Consultation Response from Alan Smith, KC Waste Strategy (Refuse & Recycling)
2026/91627 Land at, Dunford Road, Hade Edge, Holmfirth, HD9 2RT
Erection of 22 dwellings (Use Class C3) associated development including access, landscaping, ancillary infrastructure, and parking.
Date Responded: 14/07/2026 Responding Officer: Alan Smith Responding Ref: WPS 26 039

Proposed Site Layout - Option A (Site A)

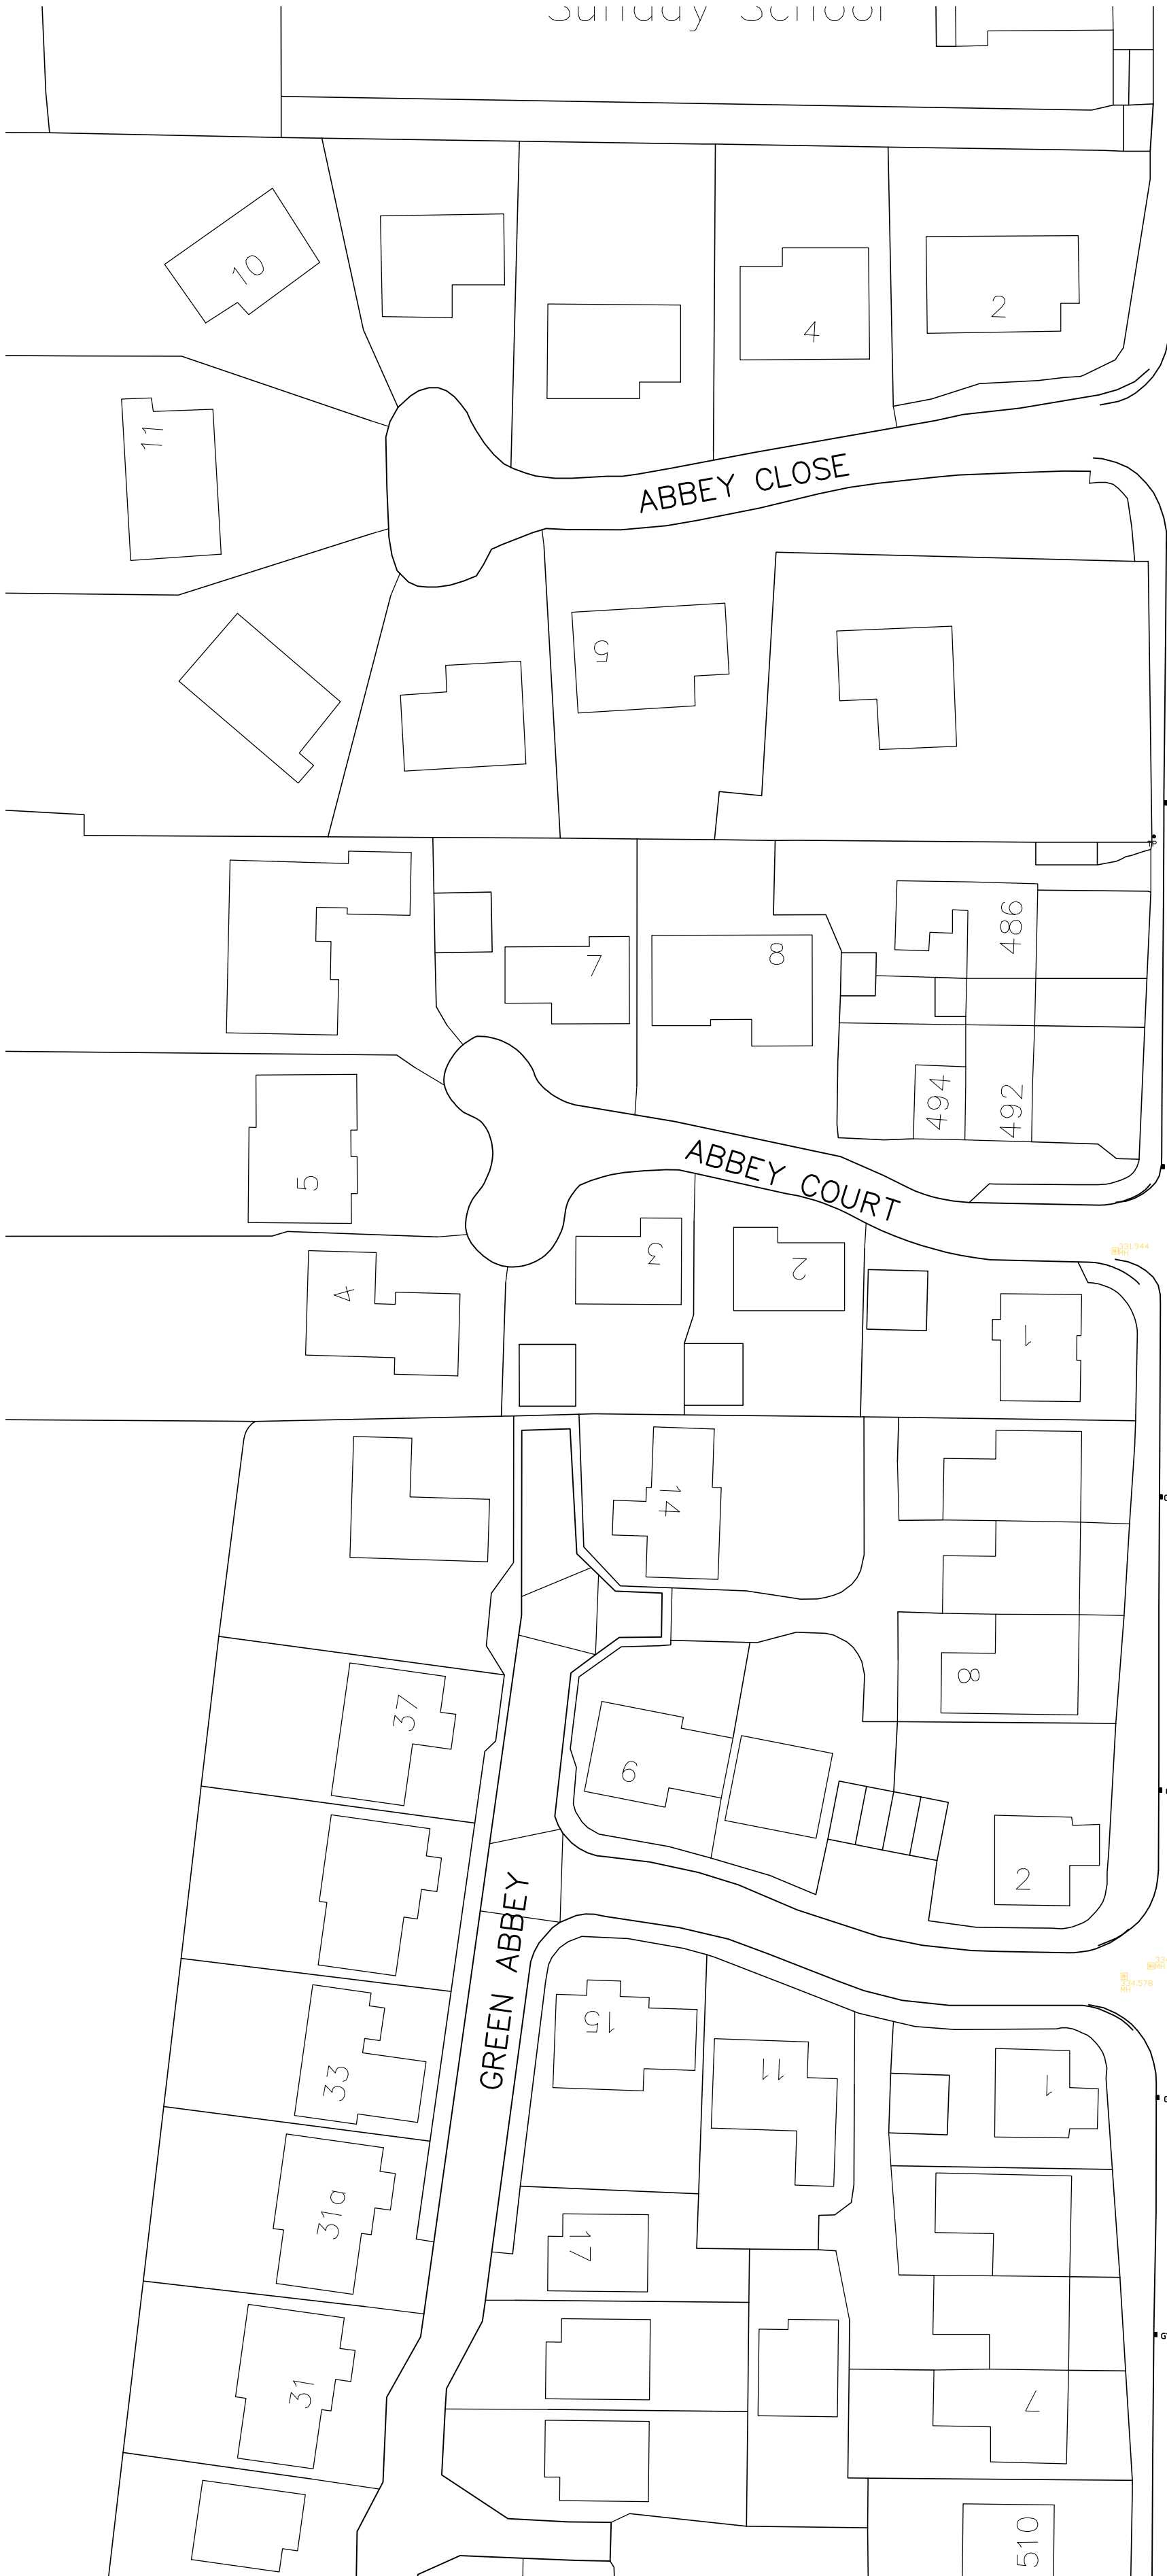
- Must be shown on a layout plan for all properties
- No gradients steeper than 1:12 or steps from storage area to BCP
- Located adjacent to an adoptable highway
- Solid surface required, resistant to constant wear and tear

- The maximum drag out distance from bin storage area to BCP is 25 m
- Temporary BCPs may be needed for early occupiers whilst the site is being built (likely collection area would be adjacent to Greave Road)
- Site specific comment
 - Plot – 12 - Where as terraced property has a long convoluted drag from the back garden to the BCP, there is a danger that the resident will leave the bin at the front of the property. Consideration needs to be given to providing this property with a bin store located at the front of their property. Storage to the front of the house should be screened and avoid wheeled bins being left adjacent to doors and under windows.

- The WCA will not enter:
 - Private drives
 - Roads not built to an adoptable standard
 - Active construction sites
- Road layout must:
 - Enable looped access (preferred over cul-de-sacs)
 - Where applicable, turning heads must be suitable for an 11.85 m RCV
 - Turning areas must be made active to avoid them being used for additional parking
- Reversing distance for an RCV must not exceed 12 m (WISH guidance)
